**Application by Cory Riverside Energy for an Order Granting Development Consent for the Riverside Energy Park.**

**Additional Written Questions**

**Q2.1.4 – Please will the London Borough of Havering comment on the Applicant’s assessment of the significance of the predicted impacts from air emissions, in particular Nickel and Chromium VI, at identified receptors in Rainham as set out in its response to the ExA’s first written questions [REP2-055]**

**London Borough of Havering response**

Predicted Annual Mean Nickel Concentration - Maximum Emission Concentration

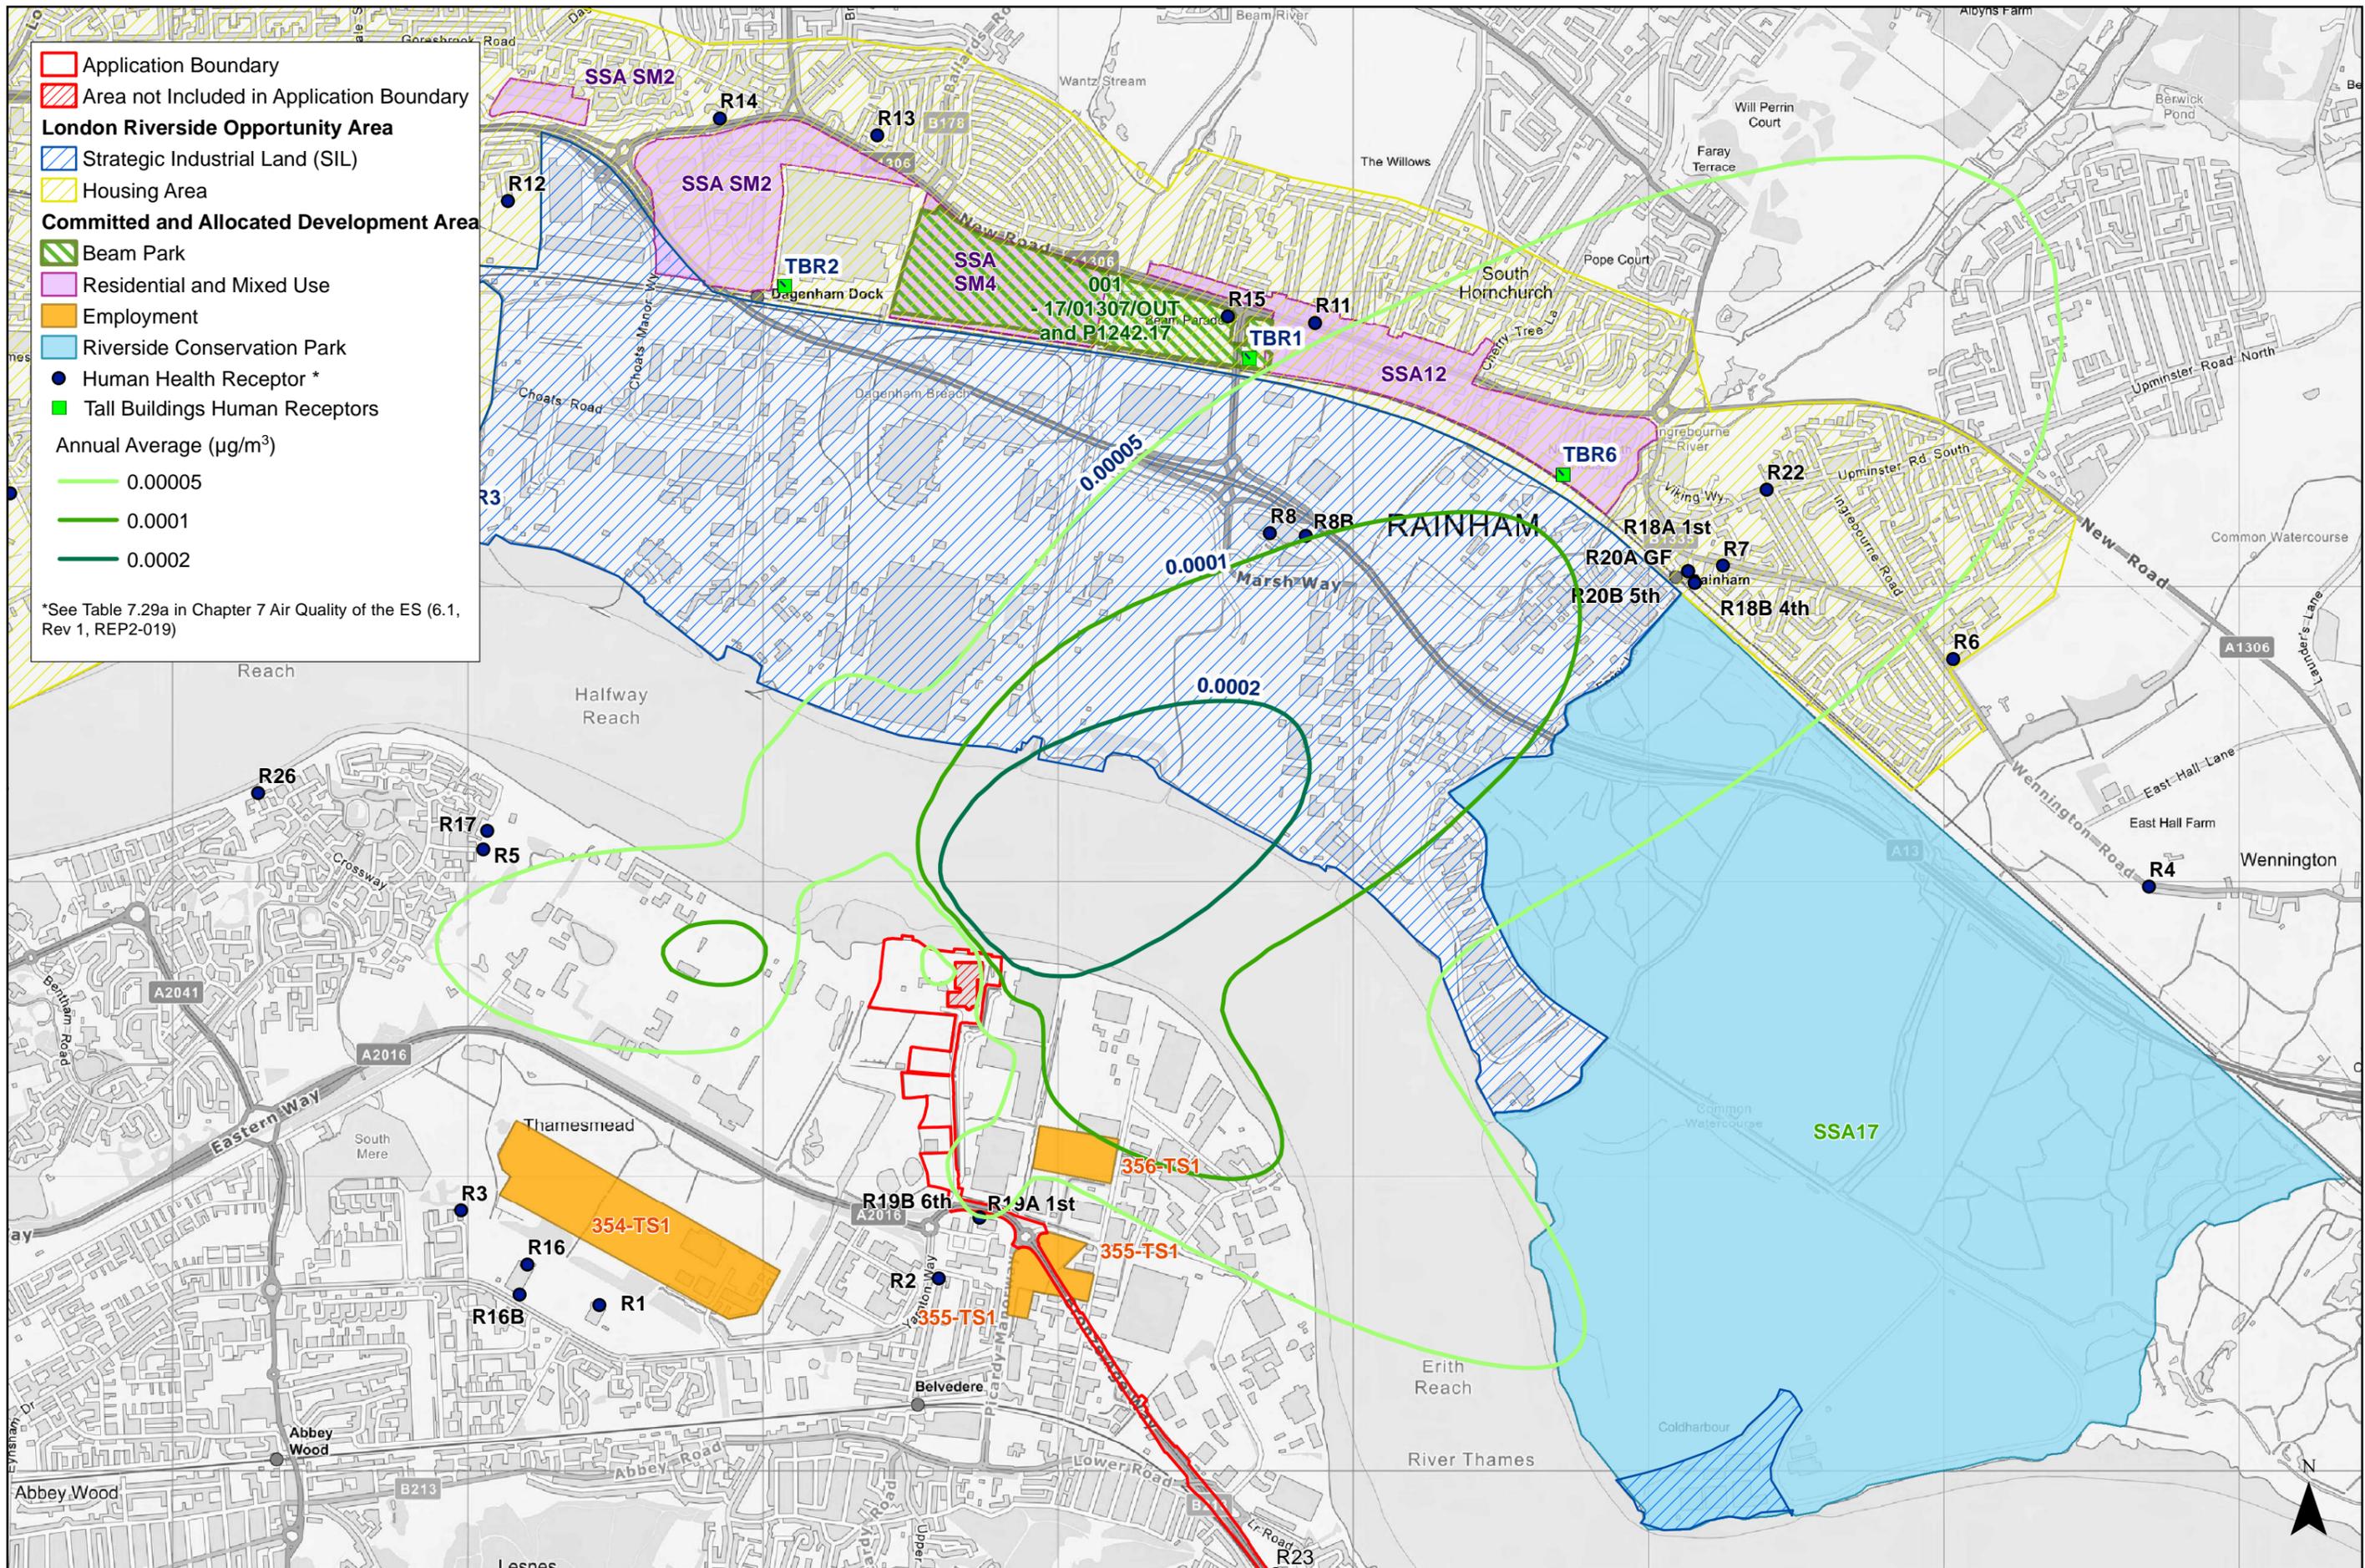
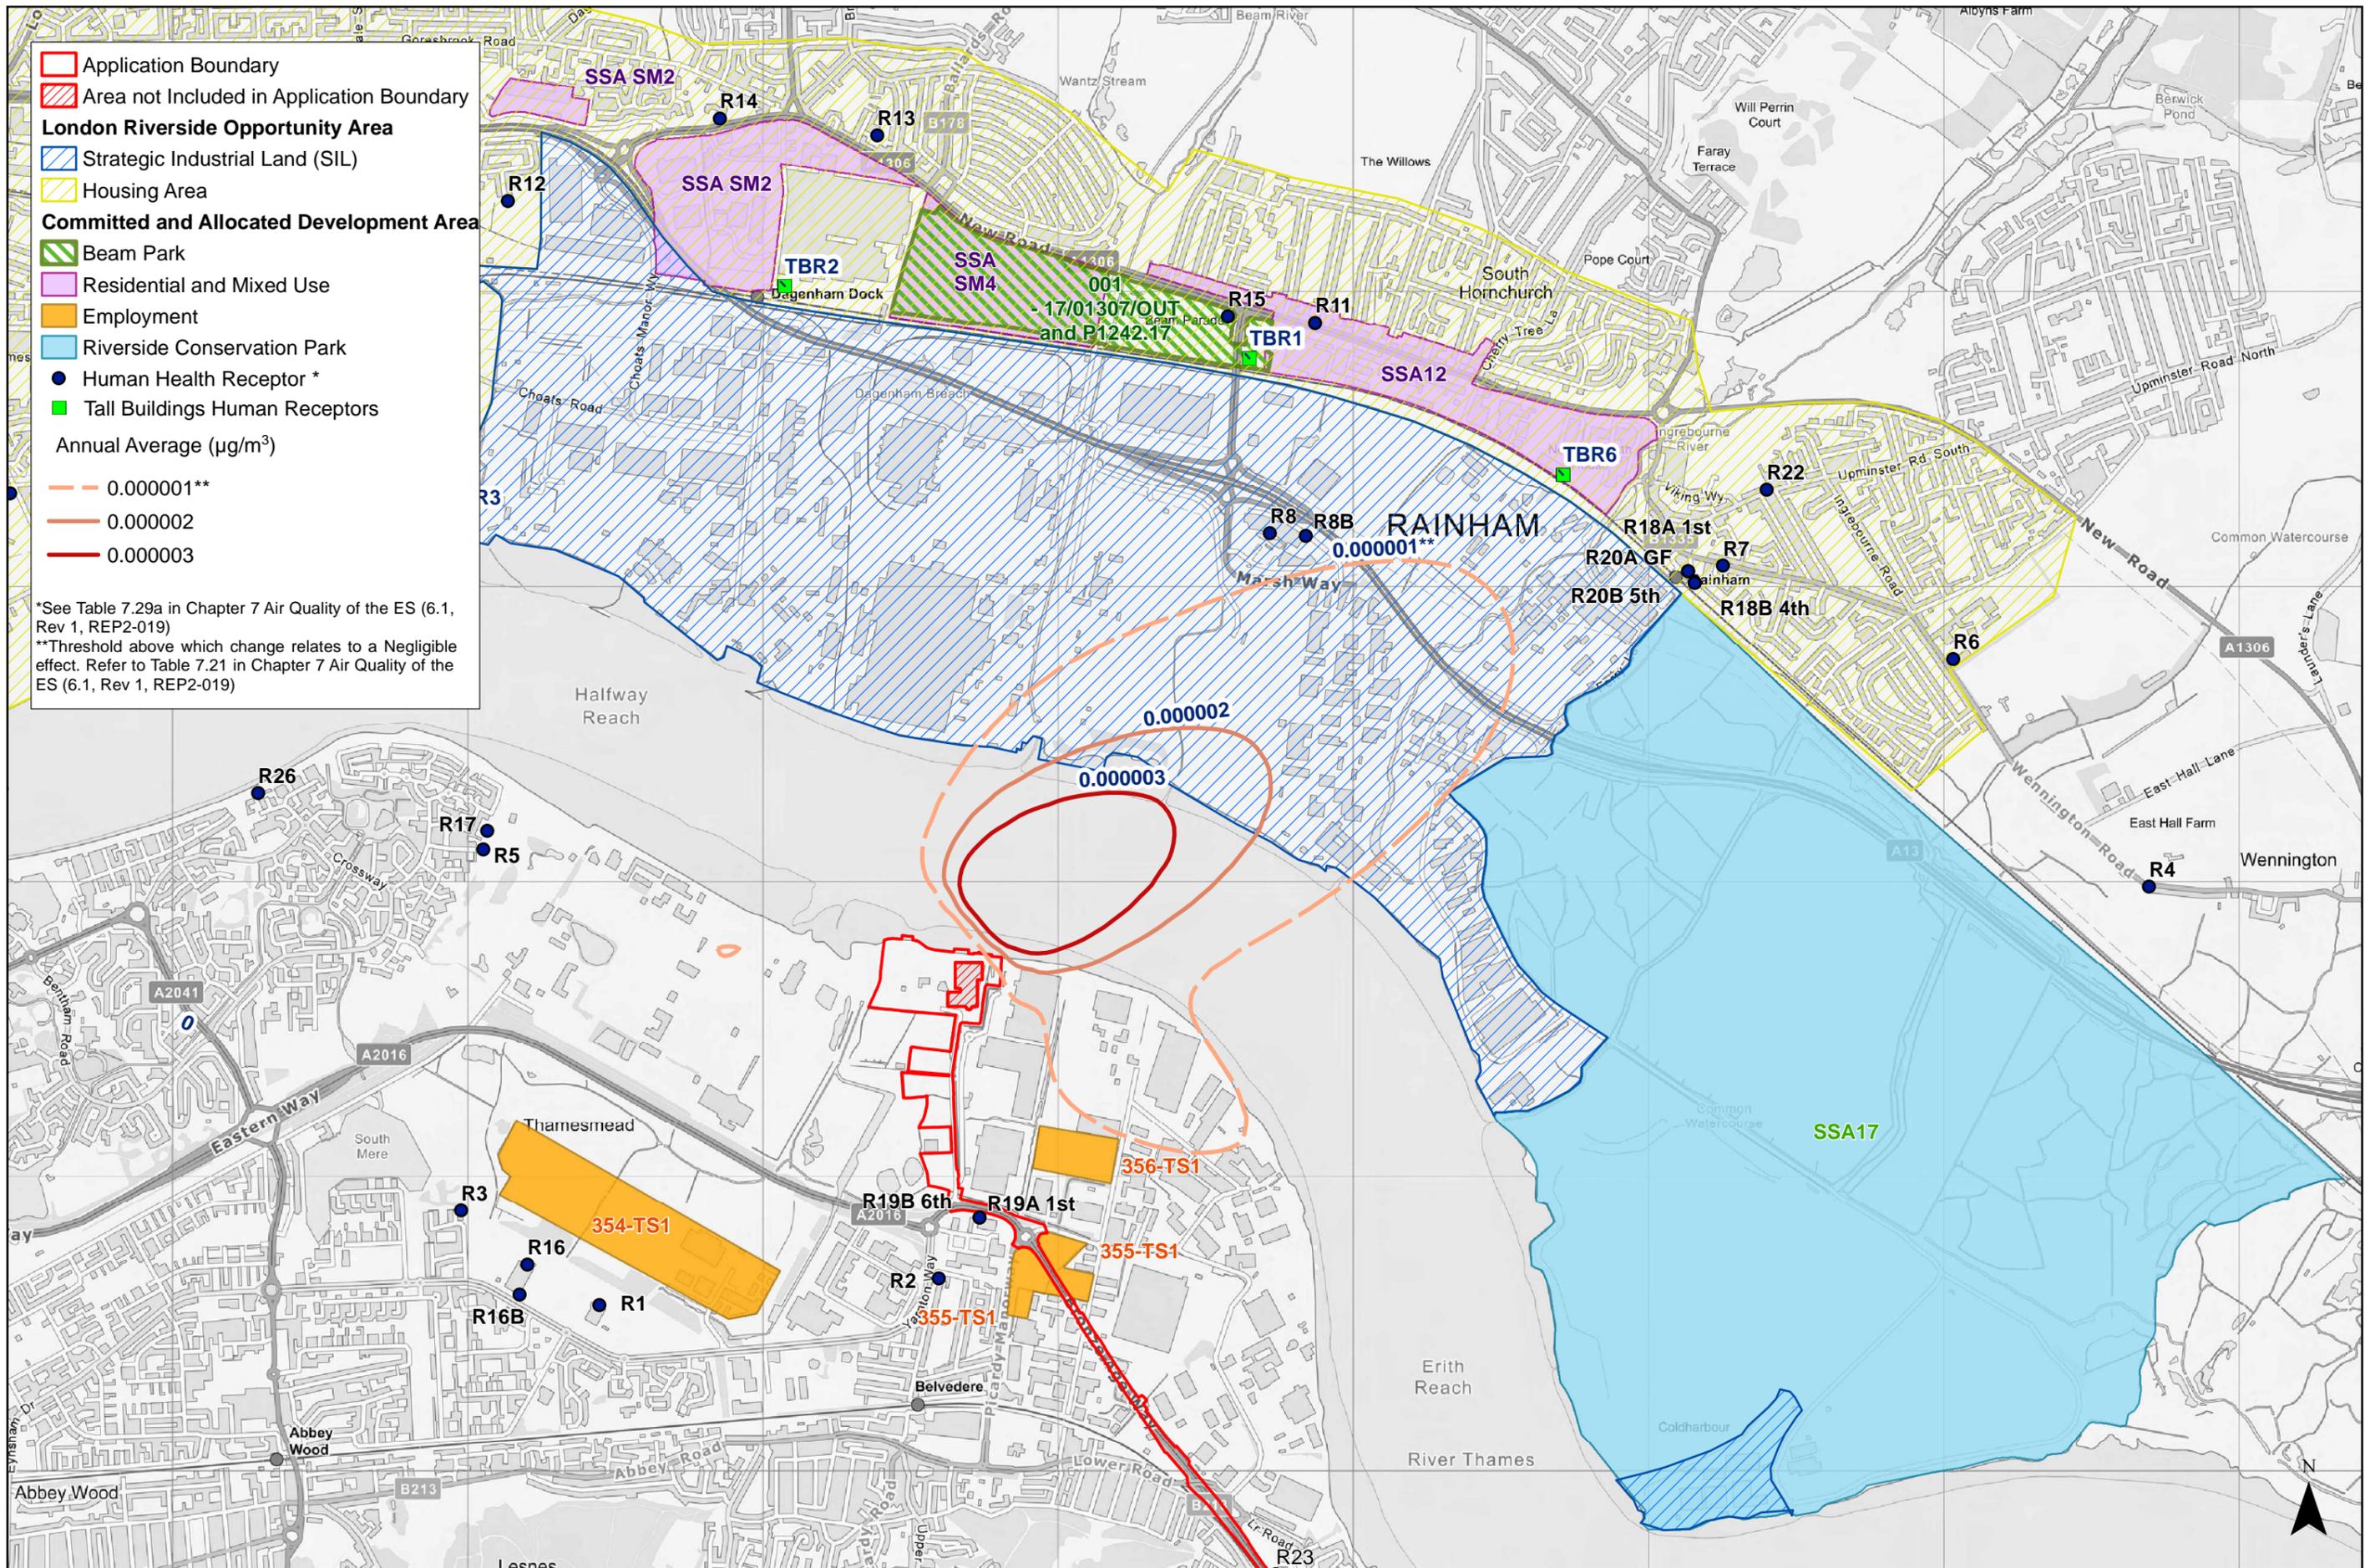
1.1 The Applicant sets out in its response (2.10.2) the factors which should be taken into account to judge the level of significance of impacts. One of these factors is the number of properties with minor, moderate or major air quality effects and a judgement on the overall balance. The Applicant balances the number of properties that receive different levels of impact across the whole of the study area (2.10.3, 2.10.4). More specifically, the Applicant’s judgement that the Minor impacts can be considered not significant, is based on the fact that the majority of receptors in Rainham and in the wider study area receive negligible impacts.

1.2 As set out in the Council’s Local Impact Report, the Council does not agree with the Applicant’s judgement of significance of impacts above and with how the IAQM guidance has been applied. According to the IAQM guidance, the extent of current and future population exposure to the impacts should be taken into account to judge the level of significance of impacts. According to the same guidance, *‘the assessor will need to consider the approximate*

*number of people exposed to impacts in the various different categories of severity, in order to reach a conclusion on the significance of effect. An individual property exposed to a 'Moderate' adverse impact might not be considered a significant effect, but many hundreds of properties exposed to a 'Minor' adverse impact could be*. Taking into account the location and type (residential) of the modelled receptors, the Council considers that hundreds of residential properties will be exposed to Minor impacts from Nickel emissions, and therefore, the extent of population exposure to these impacts is sufficiently high, to assess the impacts as significant.
